REQUEST

Current Zoning: N1-B (Neighborhood 1-B)
Proposed Zoning: N1-F(CD) (Neighborhood 1-F, conditional)

Approximately 1.99 acres located along the north side of Tom Hunter Road, west of Hidden Forest Drive, and south of I-85.

The petition proposes to allow a multi-dwelling development on a parcel currently developed with one single family detached home.

REZONING SITE PLAN

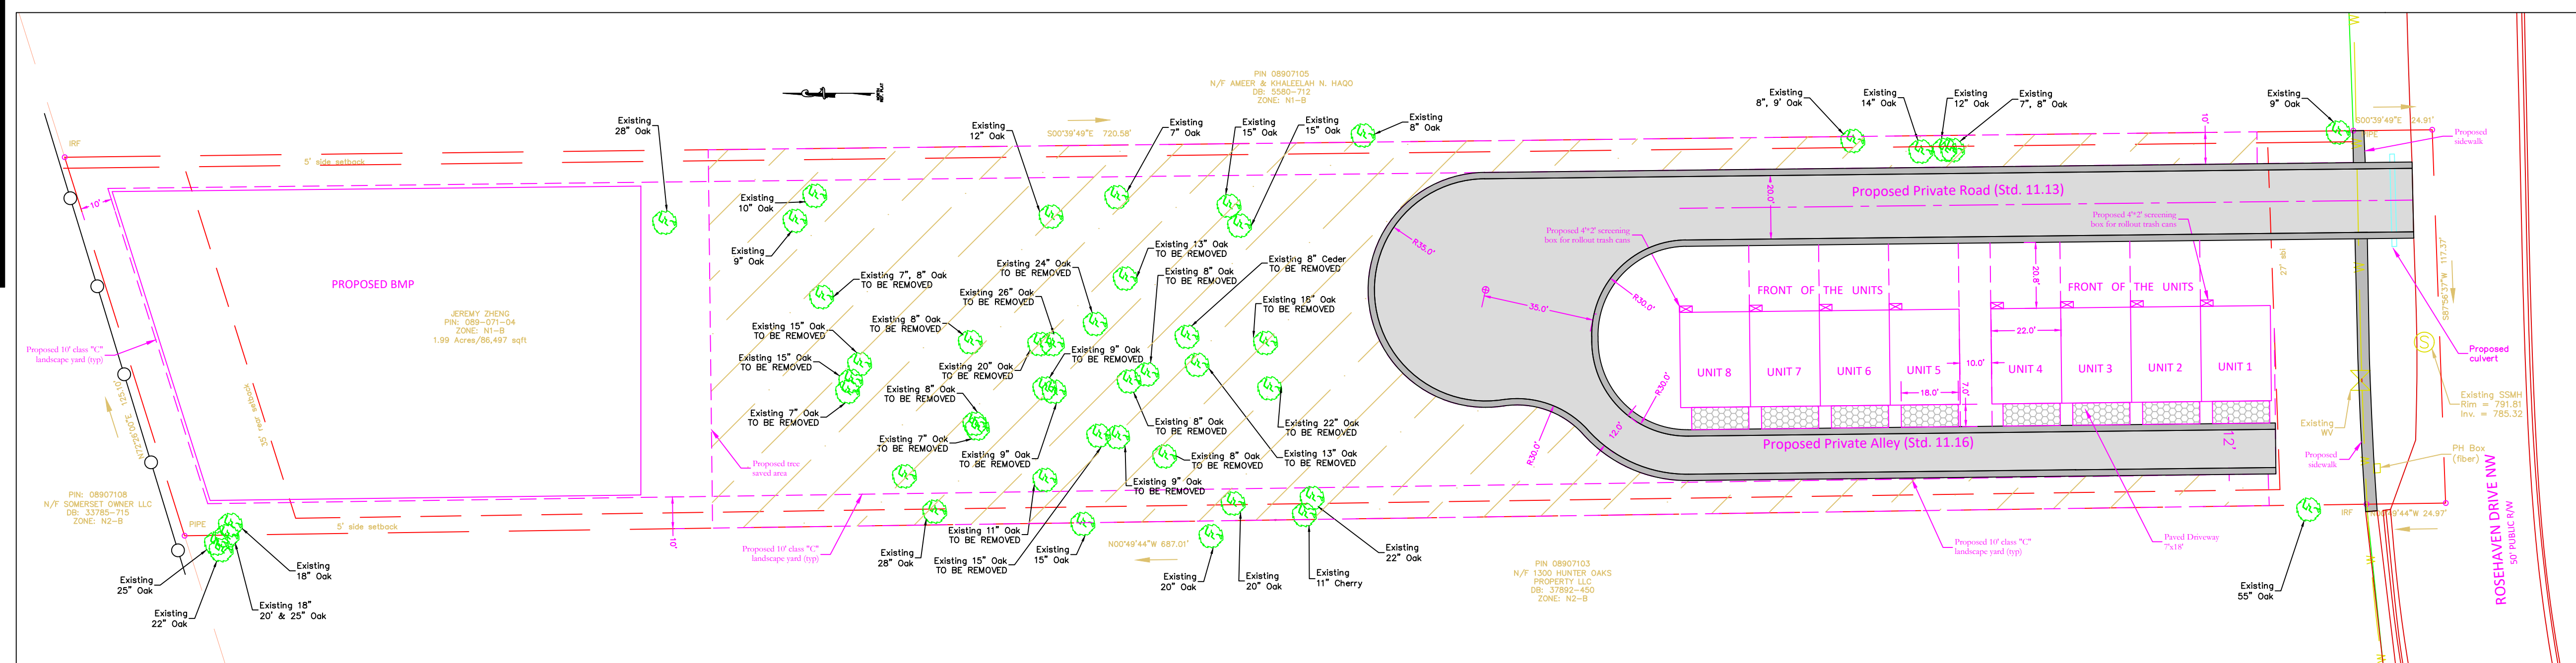
1. Label and dimension curb and gutter from the centerline. Revise the site plan and conditional notes to commit to constructing bicycle facilities by locating the curb and gutter 24' from roadway centerline.
2. Adjust the Proposed ROW to 42.5 feet, which places the ROW at the back of the proposed sidewalk.
3. Revise site plan and conditional note(s) to commit to providing cross-access to adjacent parcels per UDO chapter 31.2. Add a label to the site plan calling out cross access location.

4. Clearly label internal sidewalks connecting units to the internal private street and Tom Hunter Road.
5. Provide notes on if and how common open space areas might be amenitized.

6. Confirm in the conditional notes on which portions of the rezoning boundary the landscape yard is proposed.

7. Modify the data development table so that the rear yard reads as "rear setback" and clarify that the rear setback required is 20' and what is being proposed is 35'. Clarify in the data development table that the maximum building height allowed is 48' but 40' is being proposed, and remove reference to number of stories of the proposed building. Remove in the data development table references to the number of bedrooms and the design of the garages.

8. The "site data" section is redundant and can be removed.
 9. Move the urban design standards notes to the architectural standards section. Note six of the urban design standards regarding unit count can be removed as the plan commits to four units per building.
Transportation

10. Combine the transportation notes into one section.
Land Use
 11. Modify wording under the permitted uses to remove references to "single family attached" to be consistent with the UDO. The wording should read as eight attached units within a multi-dwelling development.
-
